CITY OF ALBUQUERQUE

March 2, 2017

Re: Red Robin at Winrock Town Center
2100 Louisiana Blvd.
30-Day Temporary Certificate of Occupancy- Transportation Development
AA Stamp dated 09-16-16 (J19-D058B)
Certification dated 03-01-17

SITE PLAN FOR BUILDING PERMIT

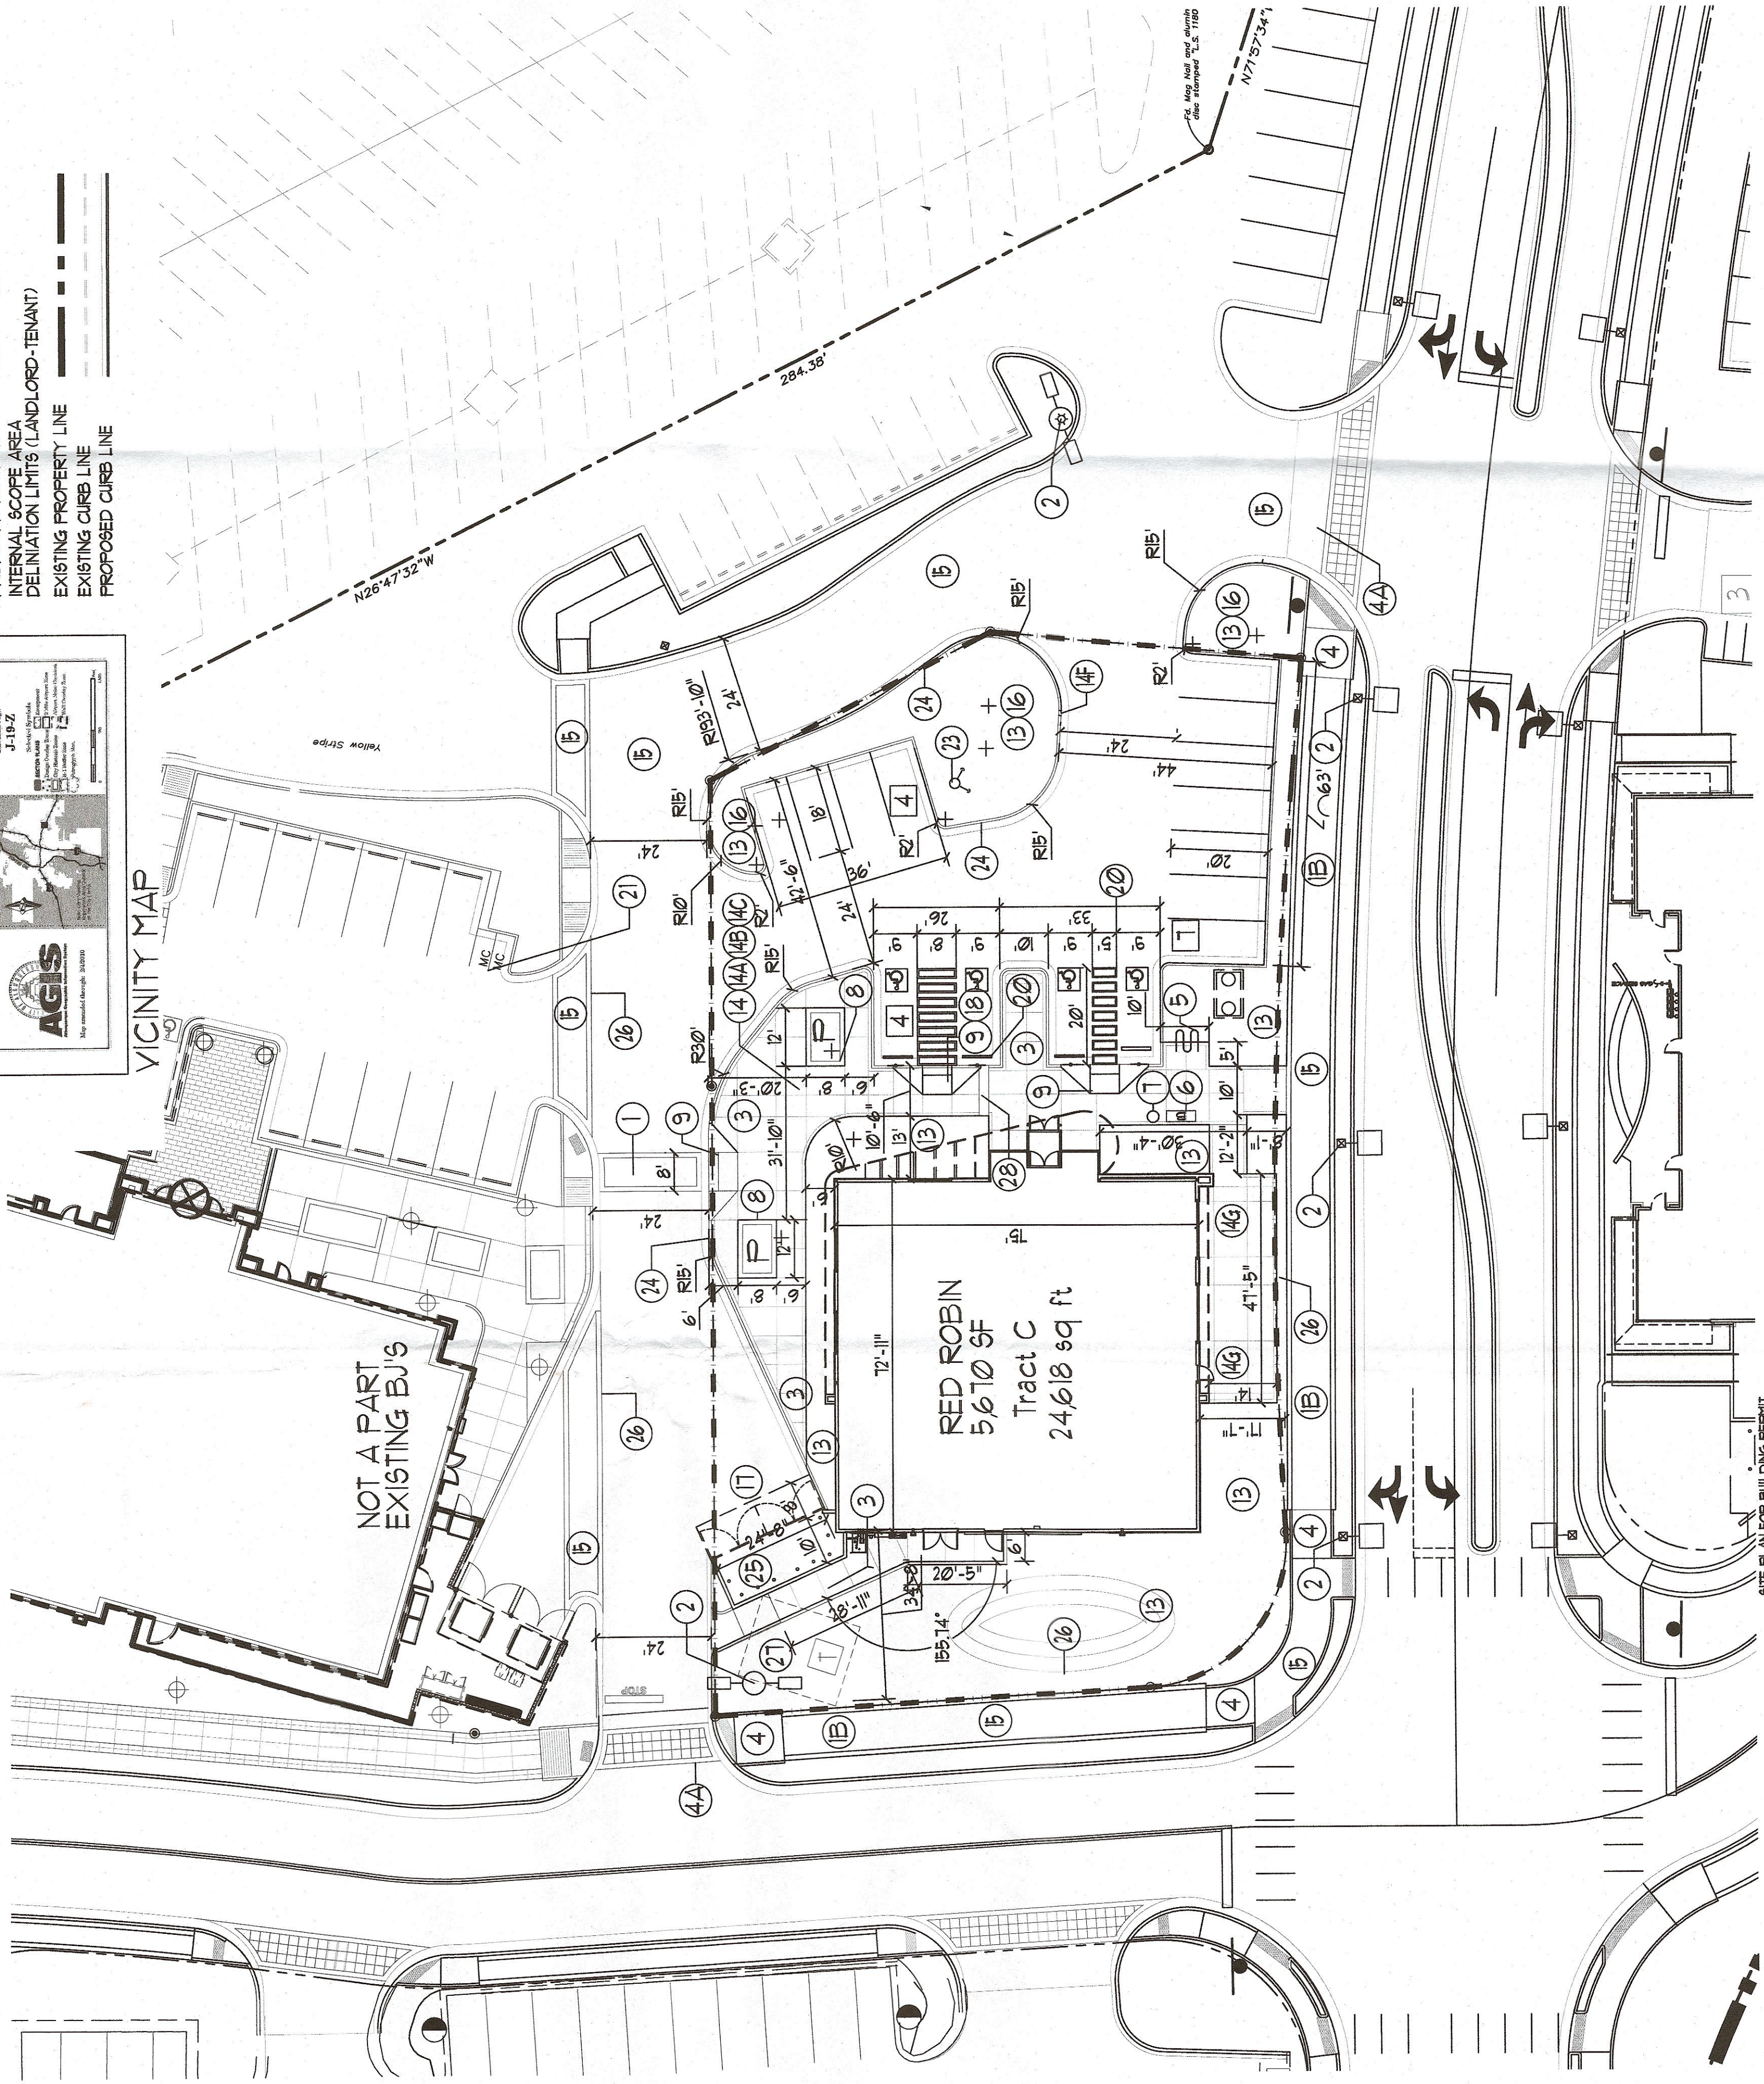
1. Motorcycle Parking needs be called out on certification plan.
2. The ADA access aisles shall have the words "NO PARKING" in capital letters, each of which shall be at least one foot high and at least two inches wide, placed at the rear of the parking space so as to be close to where an adjacent vehicle's rear tire would be placed. (66-1-4.1.B NMSA 1978)
